Planning Inspectorate NSIP ref no TR010038

A47 dualling North Tuddenham to Easton (NTE) TRAFFIC ANALYSIS

Submission from Richard Hawker IP ref No 20028320 Date: 23 November 2021

Figure 4.2: Location of 2015 traffic survey sites

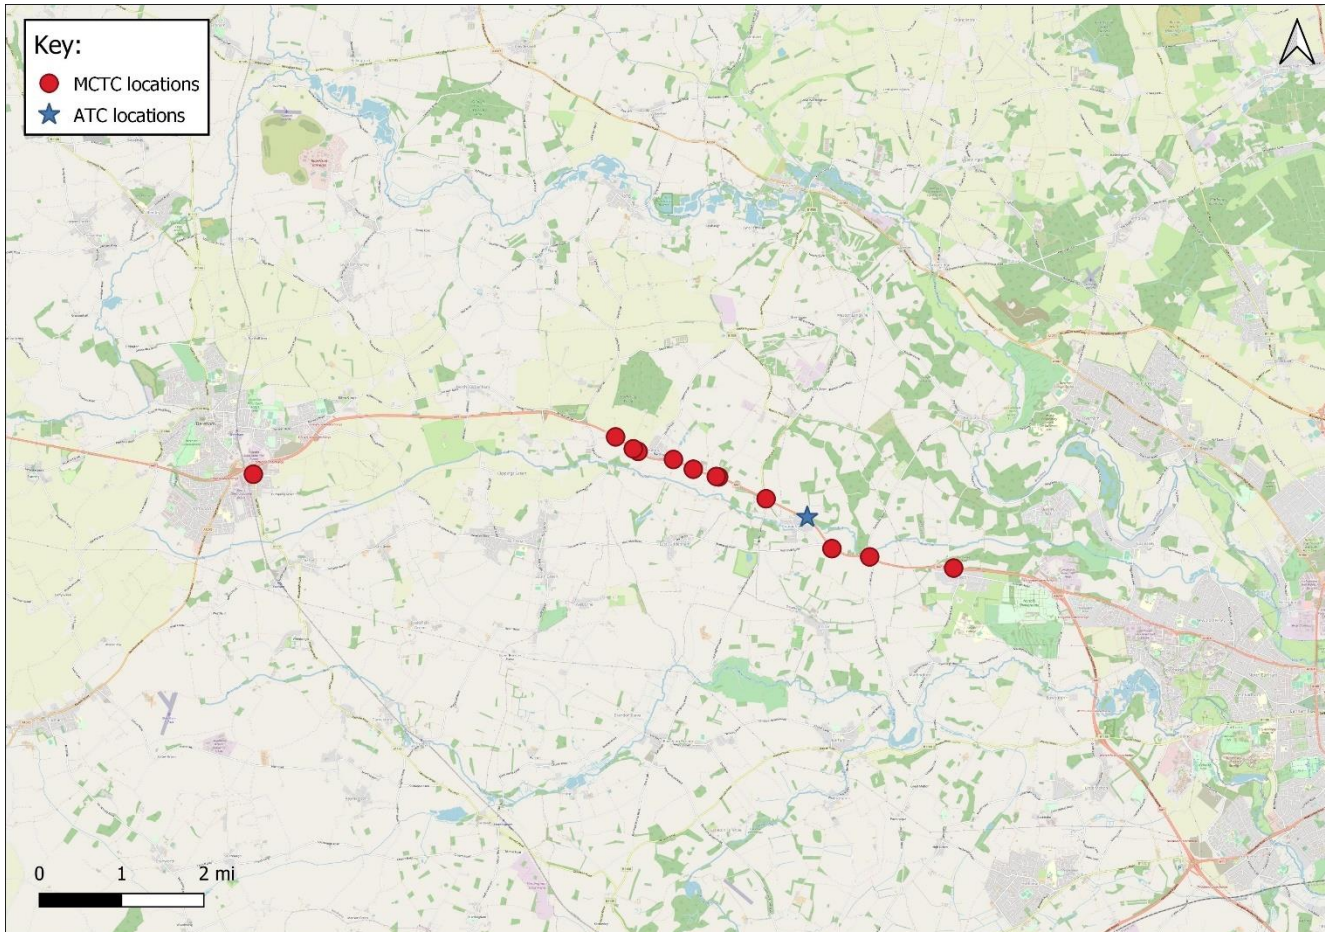
Q4 para 4.2.6, and Fig 4.2 In June **2015**, MCTC and ATC were taken. Where are the results? What did they show? Just those from a few key locations (e.g. Wood Lane) would help give confidence. There is no MCTC at Roundwell, nor Norwich Rd Costessey. These are crucial cross-valley routes, or alternatives to A47 to access city.

Figure 4.3: Location of 2016 traffic survey sites

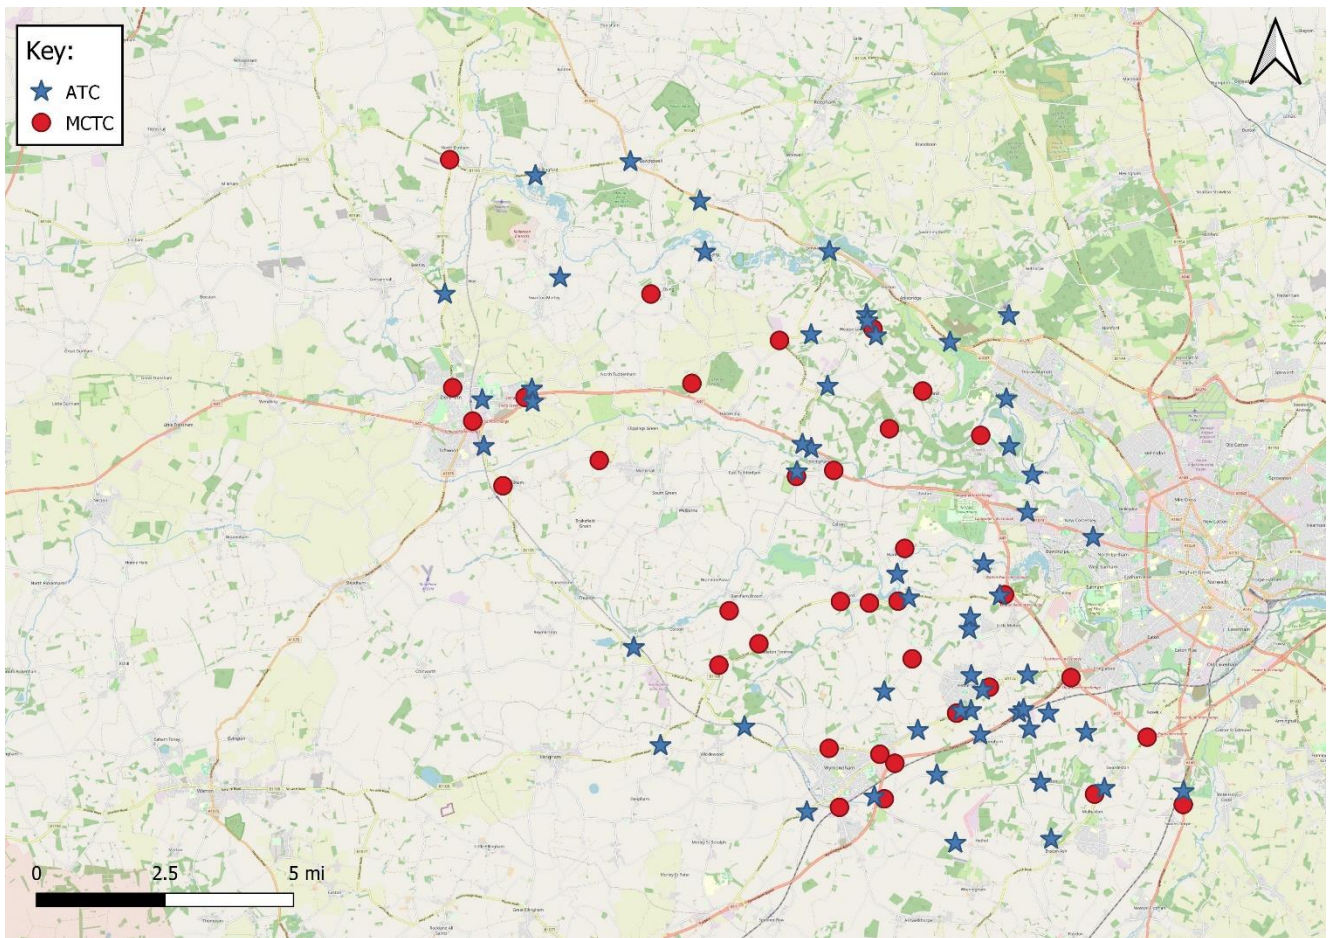
Q6 para 4.2.7, and Fig 4.3 In May, Jun, July **2016** MCTC and ATC were done 12 hours per day. Where are figures? Again, there is no MCTC at Roundwell, nor Norwich Rd Costessey. There is one shown on Ringland Lane, Costessey, on an uninterrupted stretch of road. This makes no sense. Were ATC results taken to confirm totals from the MCTCs?

Figure 4.4: Location of 2019 survey sites

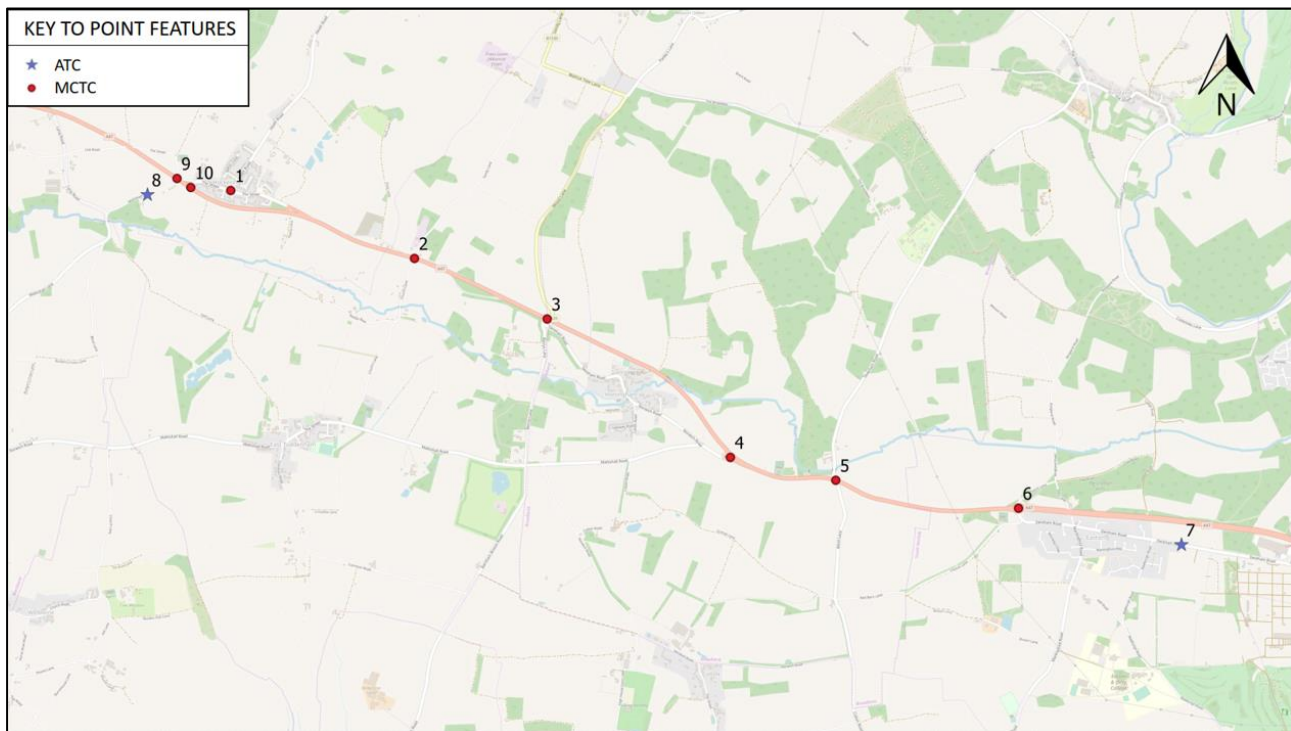
Q7 para 4.2.8 and Fig 4.4. In Oct **2019** 'Further surveys' were done. What surveys were done? Fig 4.4. shows locations (only on A47 itself). Where are figures? I have received 24-hour 5-day and 7-day AADT results from NCC, but generally excluding the locations shown on Fig 4.4.

Figure 4.5: TrafficMaster journey time data

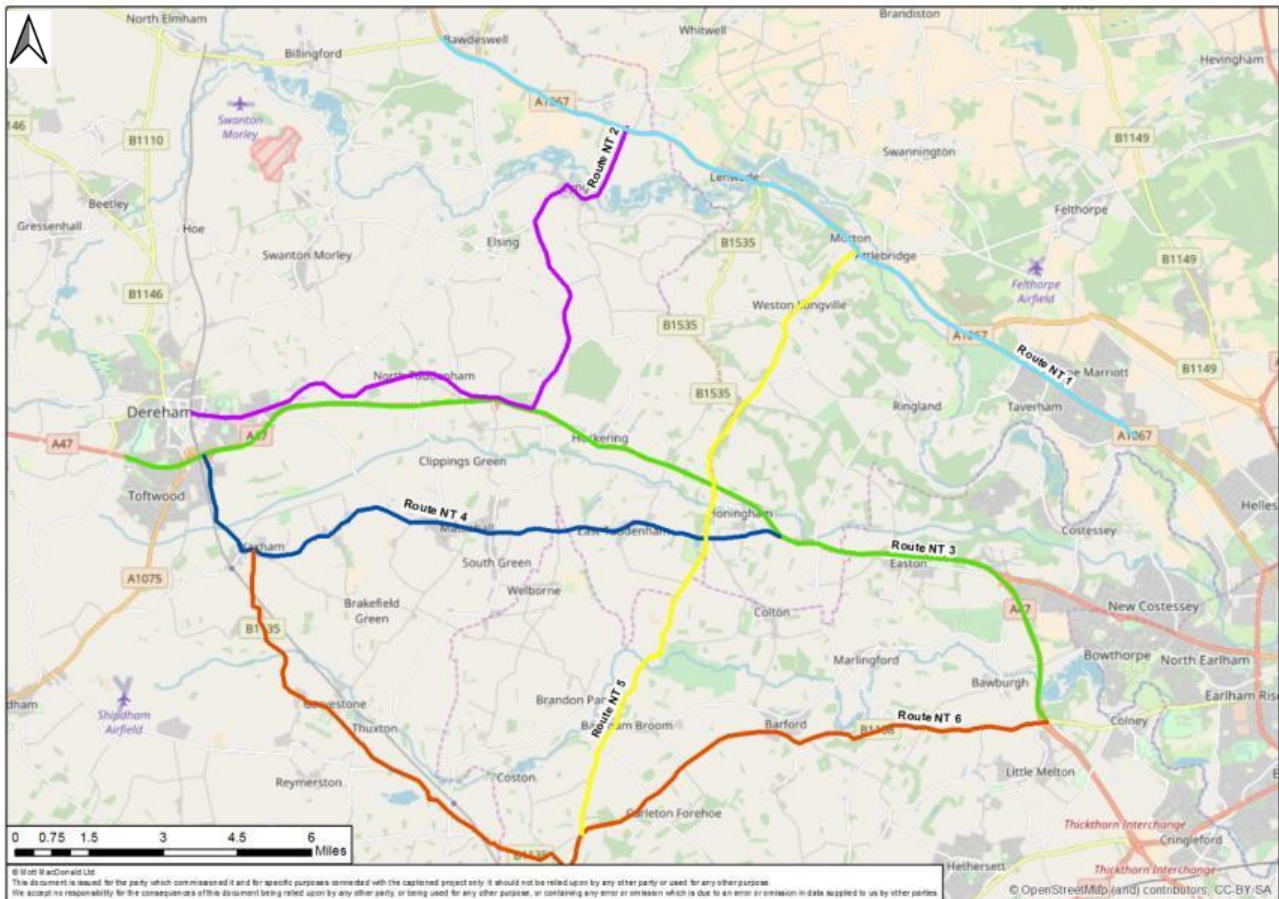
Q10 para 4.2.13 Fig 4.5 Journey time routes are shown. I describe them below with my comments. How were these routes decided upon? Some have little to do with either the A47

dualling or the NWL (NT1, NT2) or are routes which would seldom be chosen (NT6). How were journey times measured or calculated, and where are the results? What are the conclusions ?

NT1 Light Blue Bawdeswell to Drayton via A1067.

NT2 Purple Dereham to Lyng via old A47, thence to A1067.

NT3 Green Start of Dereham by-pass via A47 to B1108 jctn on Southern By-pass.

NT4 Dark Blue From Dereham via Yaxham and E Tuddenham to Honingham Rdbt on A47 (no-one calls it the Norwich Roundabout).

NT5 Yellow Attlebridge via W Longville, Berry's La, Barnham Broom to Kimberley.

NT6 Brown B1135 at Yaxham via Kimberley to B1108 then to Southern By-pass.

Figure 4.18: AADTs in Scheme area – base and core scenario

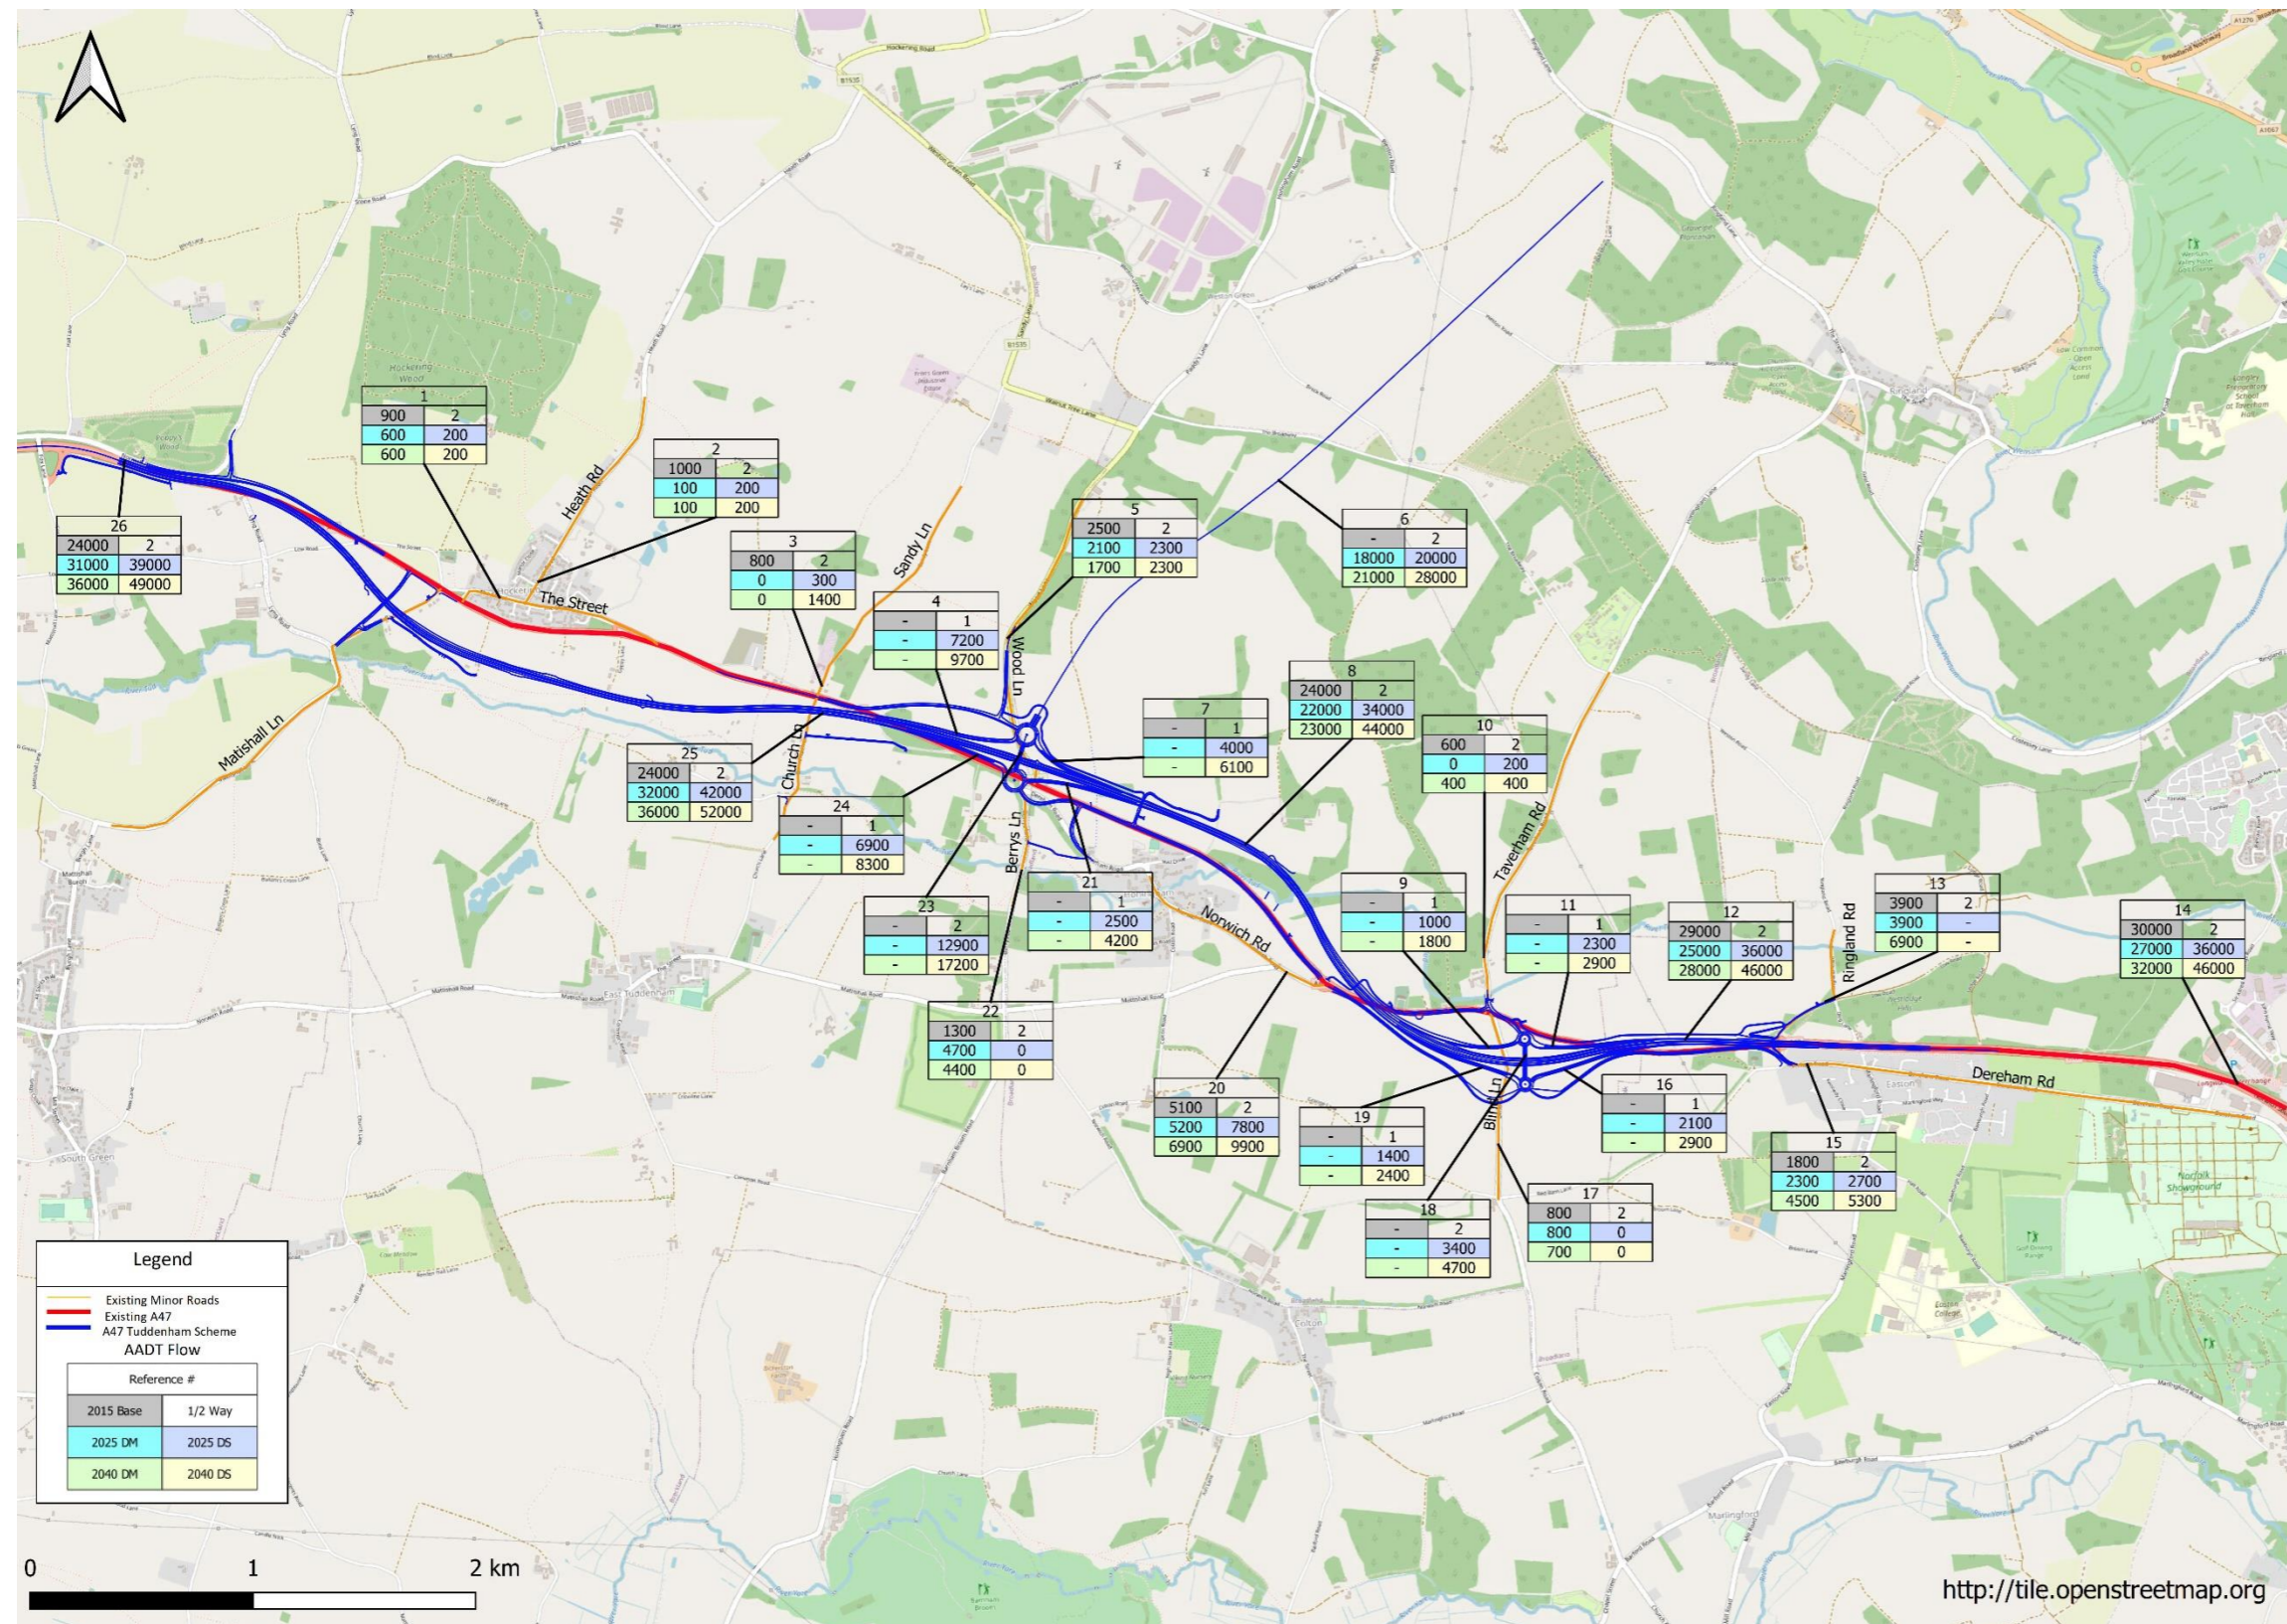
Q5 Fig 4.18 Are these 5-day AADT or 7-day AADT? Are the outputs of the NATS 2015 different from these figures?

Q18 Table 4.5 (peak-hour flows) Figures are stated as 'modelled' traffic flows for base year 2015. Are these outputs from the model, or actual survey results? Each-way flows are given for the A47; why not for the side roads? These figures refer to locations described on Fig 4.19. These do not carry numbers, and do differ in places from those on Fig 4.18. Why are they different ?

2015 –Base In absence of 1-way counts, and turning counts, analysis can only be at a basic level, using values from Fig 4.18. Running from west to east :

- 1) There is no net gain or loss of traffic on the A47 between N Tuddenham and Wood Lane. We have no figures for the A47 between these side roads (Heath Rd and Sandy Lane) so we must assume that turning movements from each are equally-divided between 'to the W' and 'to the E' .

- 2) Either side of Wood Lane junction, the A47 flow is unaltered (24k). This is surprising, as anecdotal/observational evidence is that most traffic joining from Wood Lane turns eastwards; the turn to the west is difficult, and HGVs are advised not to do so. Similarly the turn from Berry's La eastwards is difficult, and it would be easier for traffic to join at Honingham roundabout. Even assuming a 75/25 split, west/east, 1,000 would join the A47 westwards. Therefore one would expect an minimum increase of around 1k here, rather than no change. **This needs to be investigated.**

- 3) Around 5k join the A47 at the Honingham roundabout, giving a mainline flow of 29k (24k + 5k). This is reasonable. The 'double back' turn from Mattishall Road to the A47 is seldom used.

- 4) The flow on the Easton by-pass is 30k, just 1k more than just before the roundabout. But the flow through lower Easton is 3.9k. Even if one assumes that only half of this turns E (not borne out by anecdotal evidence), there should be around 2k extra on the bypass, even without the contribution from Easton Street, which may be around 900. **Therefore around 2,500 – 3,000 vehicles are unaccounted for. This requires investigation.**

2) Fig 4.18 figures are not defined as 5-day or 7-day AADT (Annual Average Daily Traffic)
